**Our Case Number:** ABP-317121-23

**Re:** BusConnects Swords to City Centre Bus Corridor Scheme  
Swords to Dublin City Centre

# Swords to City Centre Core Bus Corridor Scheme Submission (Ref. No. 317121)

Submitted on Behalf of:  
Collinstown Caravans Limited  
Airport Road, Dardistown, Cloghran, Co. Dublin.

Programme Title BUSCONNECTS DUBLIN CORE BUS CORRIDORS INFRASTRUCTURE WORKS			
Drawing Title SWORDS TO CITY CENTRE CORE BUS CORRIDOR SCHEME TRAFFIC SIGNS AND ROAD MARKINGS			
Drawing File Name	Sheet Number	Status	Rev
BCIDB-JAC-TSM_GA-0002_XX_00-DR-CR-0013	13 of 37	A	M01

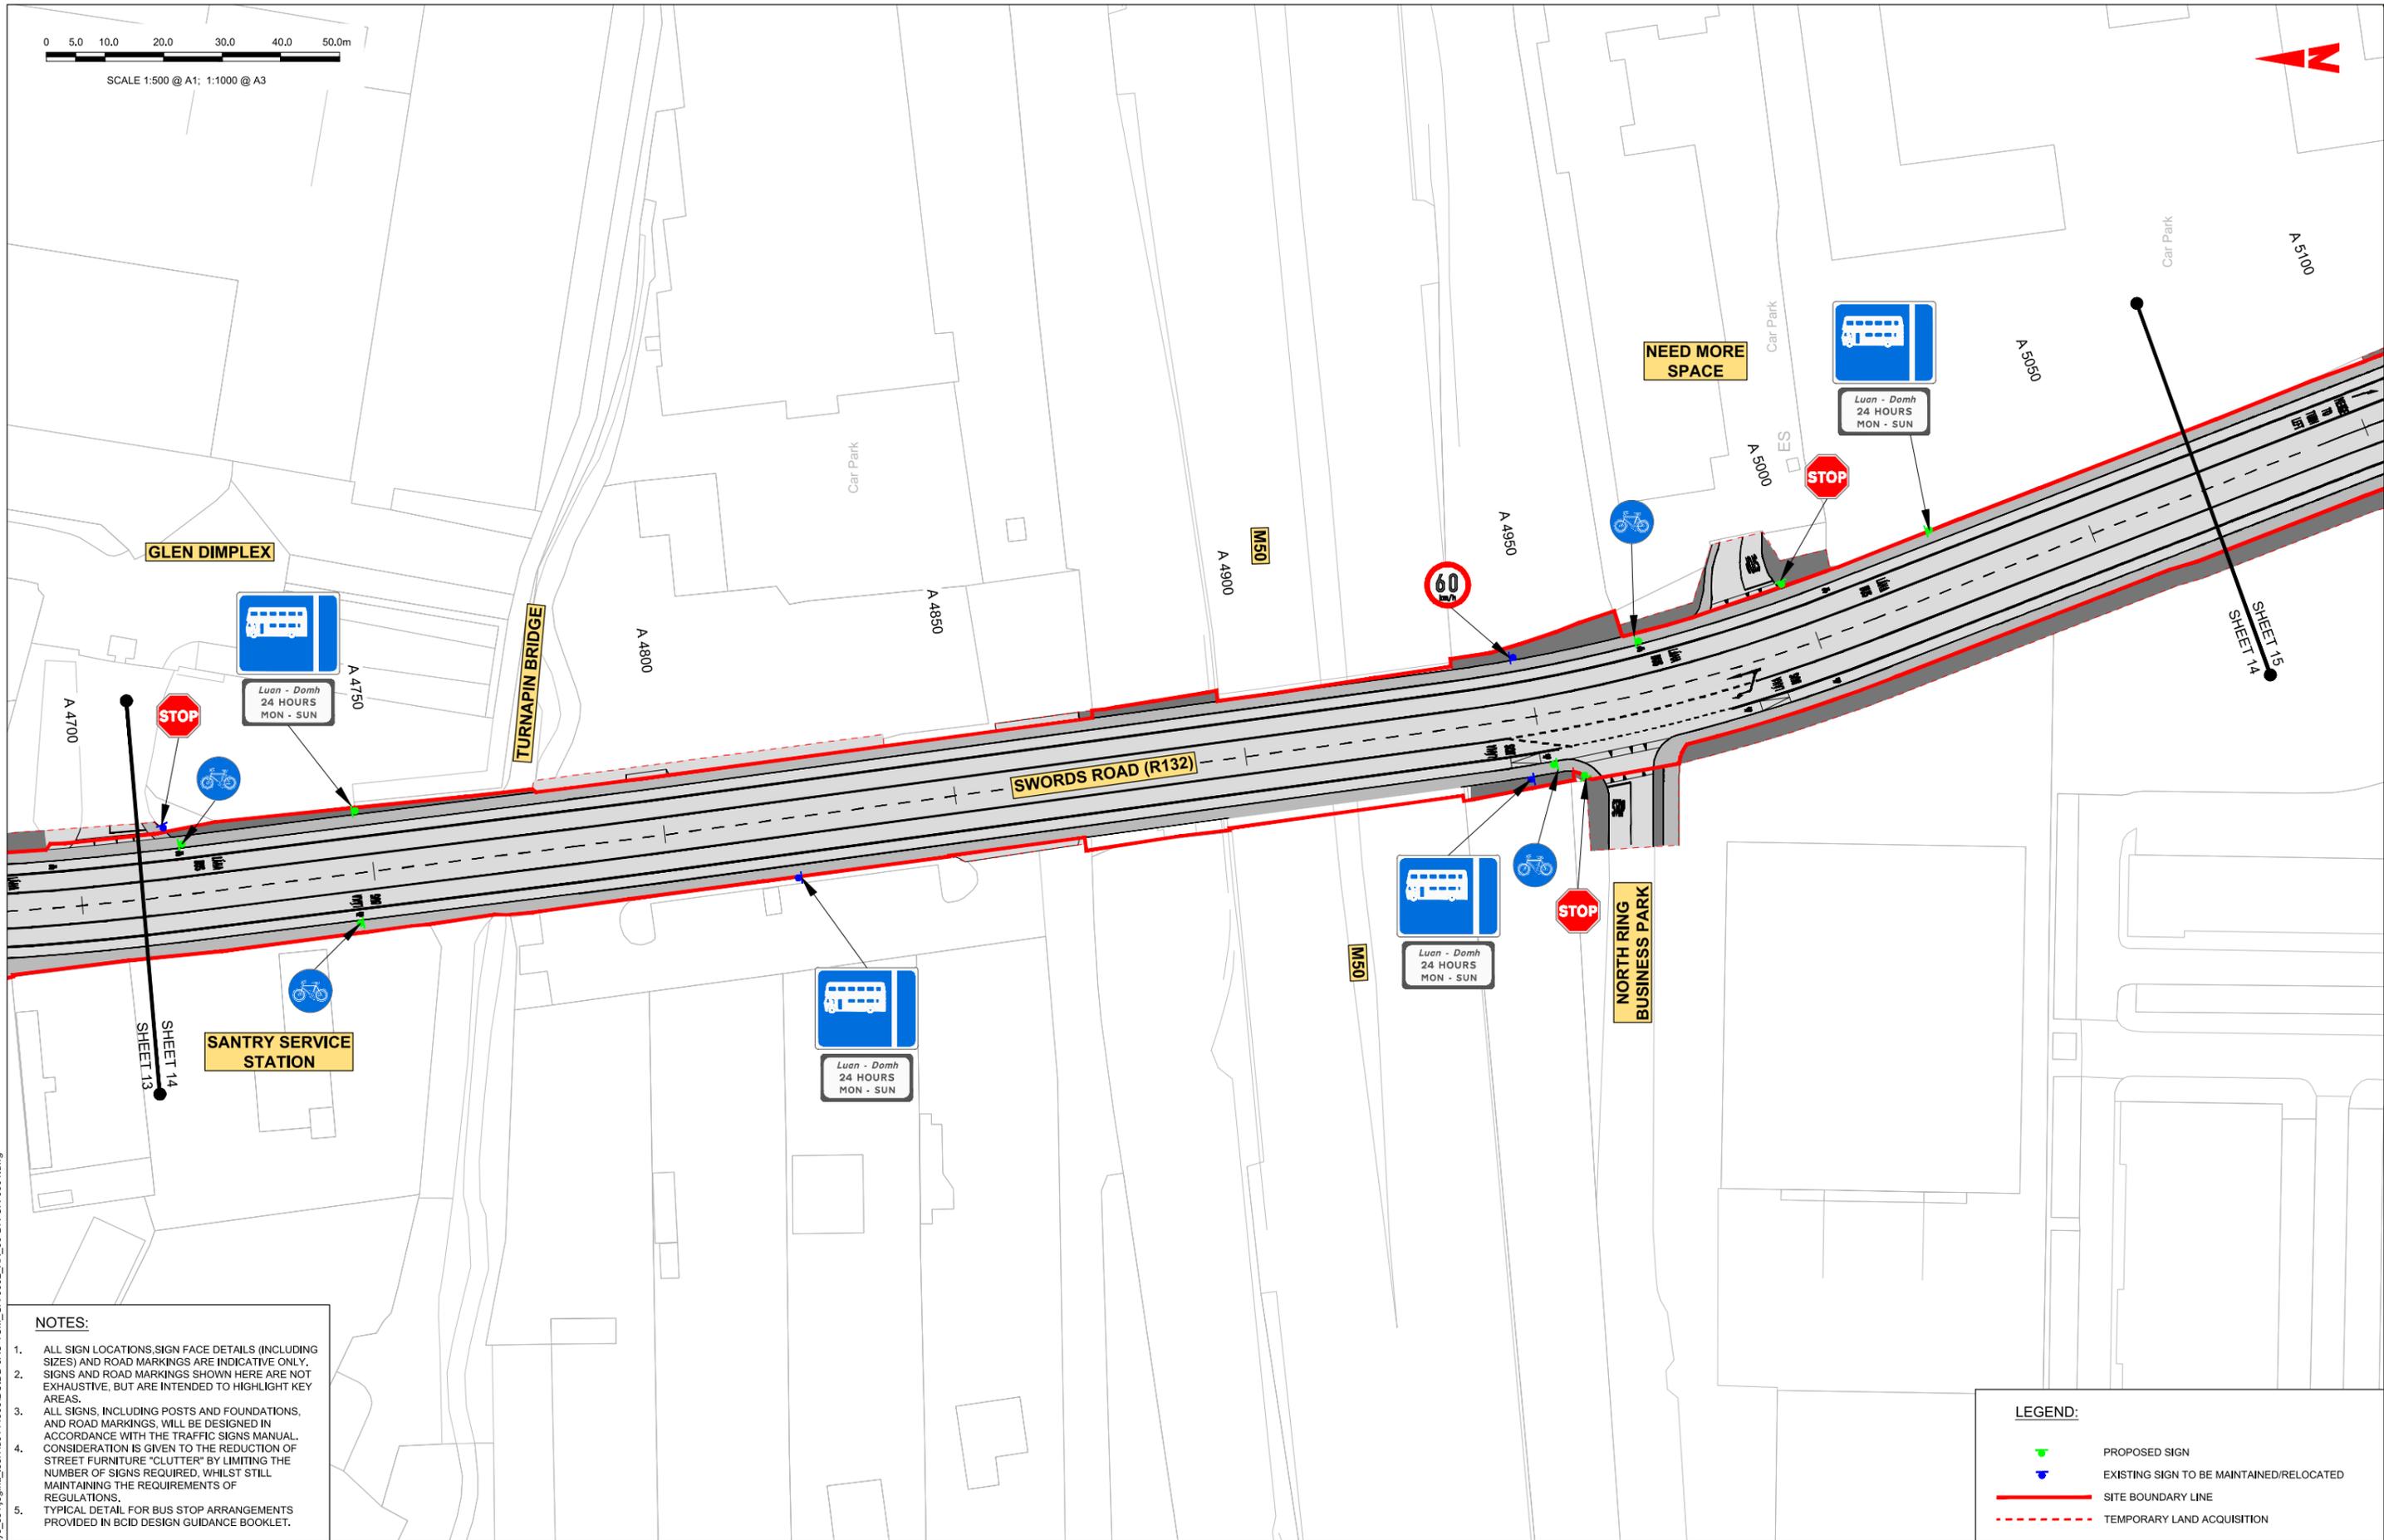
1. The extant residential dwelling will be rendered inaccessible with no pedestrian and/or vehicular access to the Swords Road; and,
2. Direct impacts to the residential amenity of the property including visual impact, noise, light pollution and vibrations.

Further to the above, the scheme will also provide for a significant revision of existing boundary treatments/planting between the subject site and the adjoining road network along its western boundary.

As identified in Figure 5.0, above, the ancillary works provided under the Swords to City Centre Core Bus Corridor Scheme will render the existing dwelling on our client's site as inaccessible with the existing pedestrian/vehicular access replaced with a new grass verge. Indeed, review of the general arrangement drawing would suggest that there will be no new boundary treatment provided and, as such, the existing dwelling will be separated from the roadway by a grass verge adjoining its front garden. The provision of the grass verge is not considered to represent any significant improvement of the visual amenity of the area.

Without a means of accessing the subject site, whether for pedestrians or vehicles, this would effectively necessitate the abandonment of the subject property for which, as per the recent planning application on site, the residential use was intended to be maintained. Moreover, without a means of accessing the site, the subject property would not be able to be removed and would remain as a blemish on the local landscape.

The purpose of a boundary wall is, in the first instance, to demarcate the boundaries of the property and protect the site and home from animals, thieves, and others. Given the location of the subject site on a busy road proximate to the airport and multiple large scale commercial operations, the lack of a boundary wall represents a serious health and safety hazard by removing any barrier to prevent vehicular crashes from encroaching on to the subject site. With no discernible boundary to the roadway, our client will suffer a direct compromise to the financial value of their property and we would appeal to the NTA to consider the impact of the provision of a grass verge at this location.

Given the limited nature of the general arrangement drawings available for review in connection with the subject scheme, our client has concerns in relation to the visual impact of the scheme arising both in relation to the extended Swords Road roadway and the new pedestrian, cyclist and bus infrastructure. With regards to visual impact, the primary impact relates to the reduced separation distance between the western boundary of our client's property and the Swords Road.

Due to the position of the roadway relative to our client's site, it is assumed that the boundary treatment, which effectively doubles as a noise barrier, will be constructed to match the height of the existing fence. Simply put, the relocated vegetation and boundary fence will be situated approximately 3m closer to our client's property than at present thus resulting in an oppressive aspect when viewed from our client's property. Moreover, it is considered that the relocated boundary treatments will present an undue overbearing impact which will make the front garden appear more cramped and less open than at present.
